# Planning Consultation Response

**Reference Number:** 20/02325/FUL

**Address:** 55 Nye Dene, Sunderland, SR5 3DP

**Proposal:** Erection of two storey side extension and single storey extension to front. Extend paved area to front.

Drawing:
Proposed Plans & Elevations

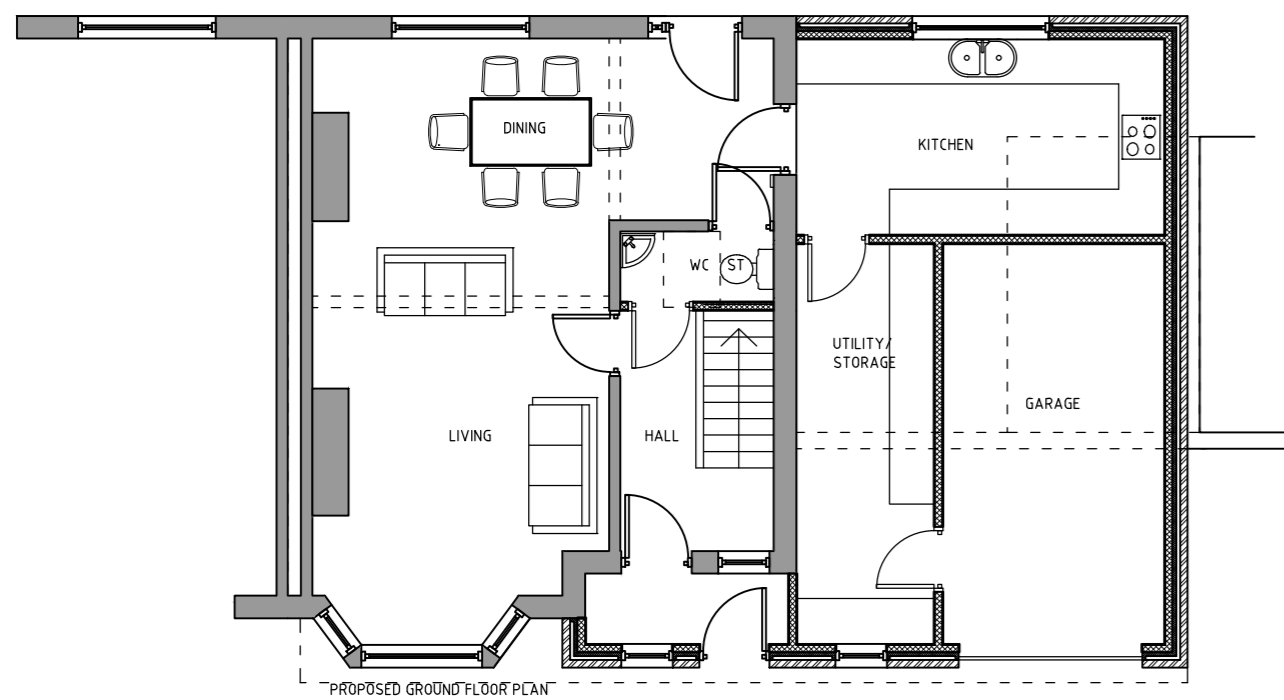
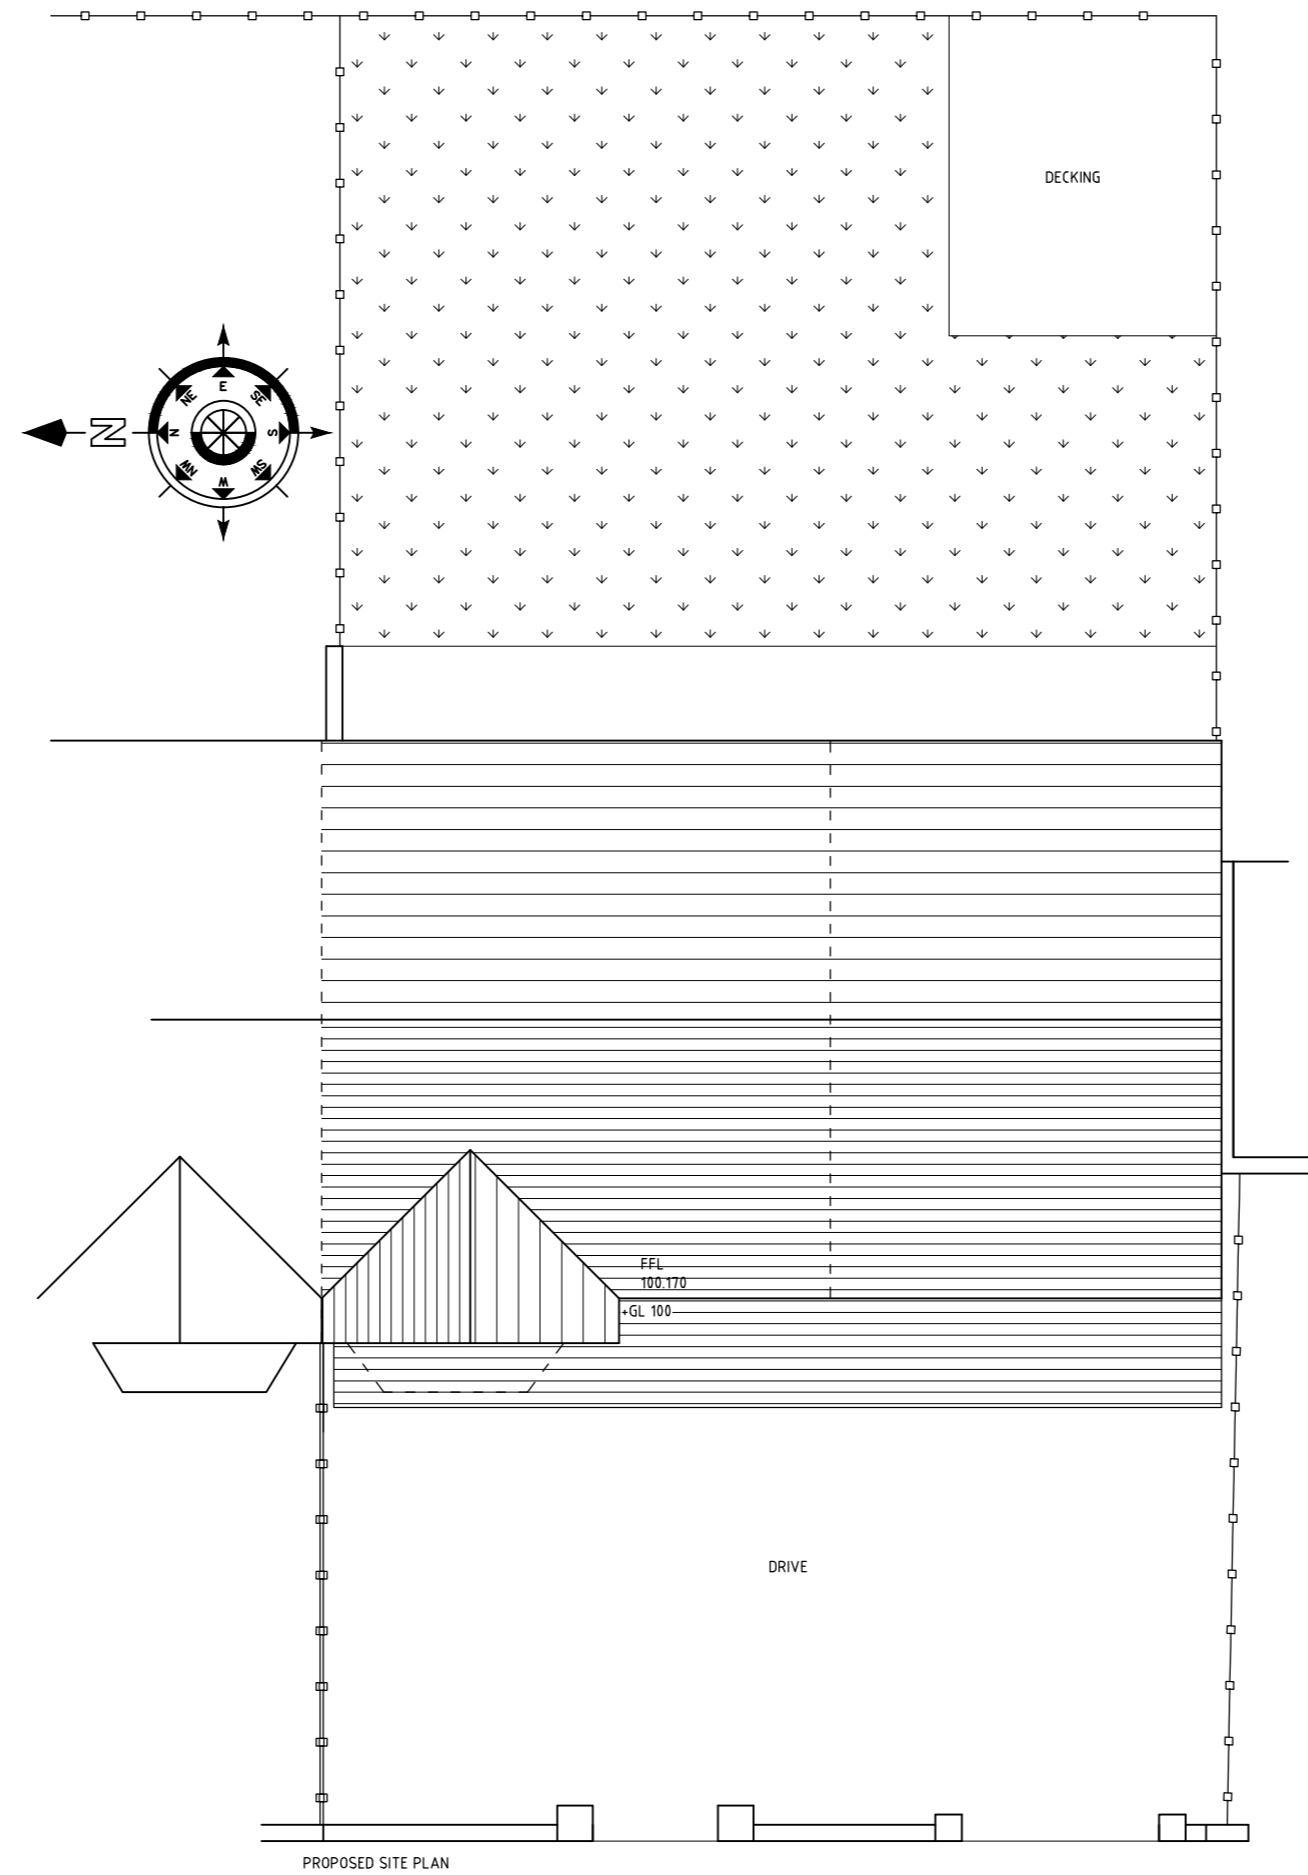
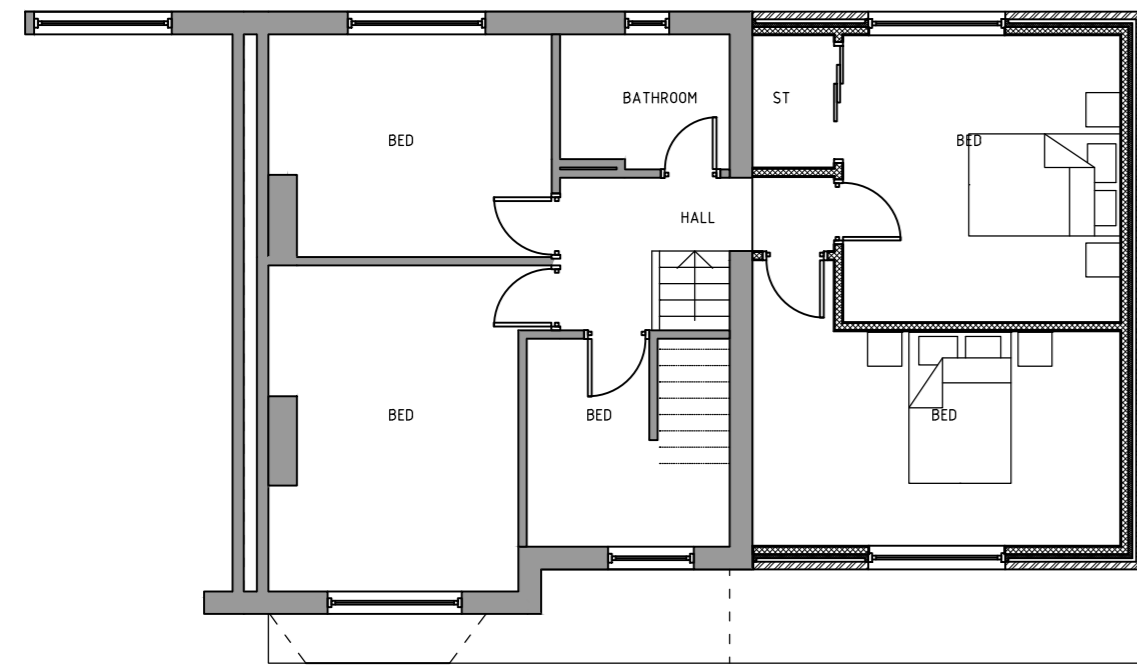
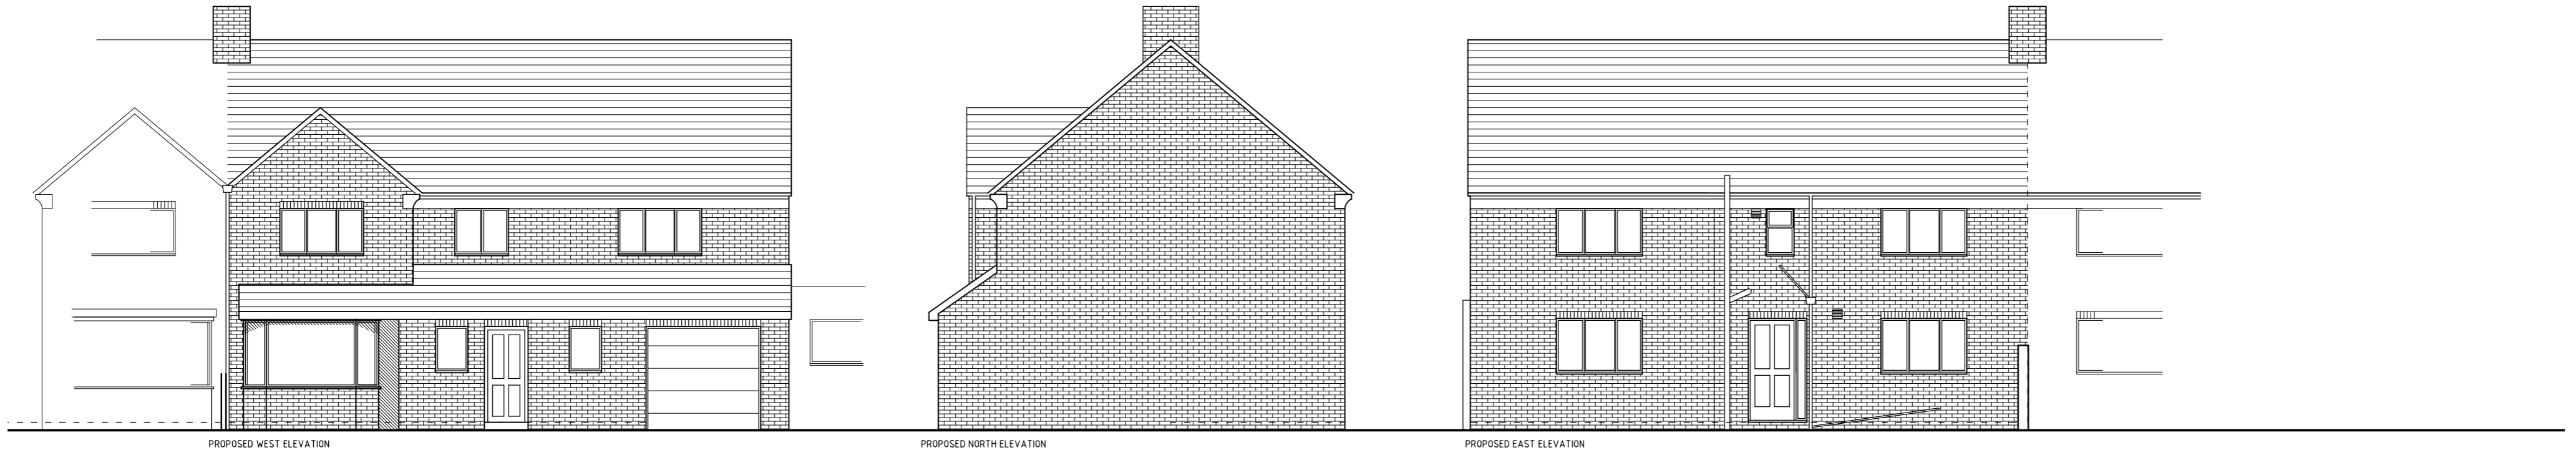
It is required that a minimum 5m long drive is provided within the curtilage of the property with a roller shutter garage door or a 5.5m drive with an up and over garage door, to avoid any overhang on the footway/highway.

It would appear that this is the case with this proposal and therefore Transportation Development has no objection to the application.
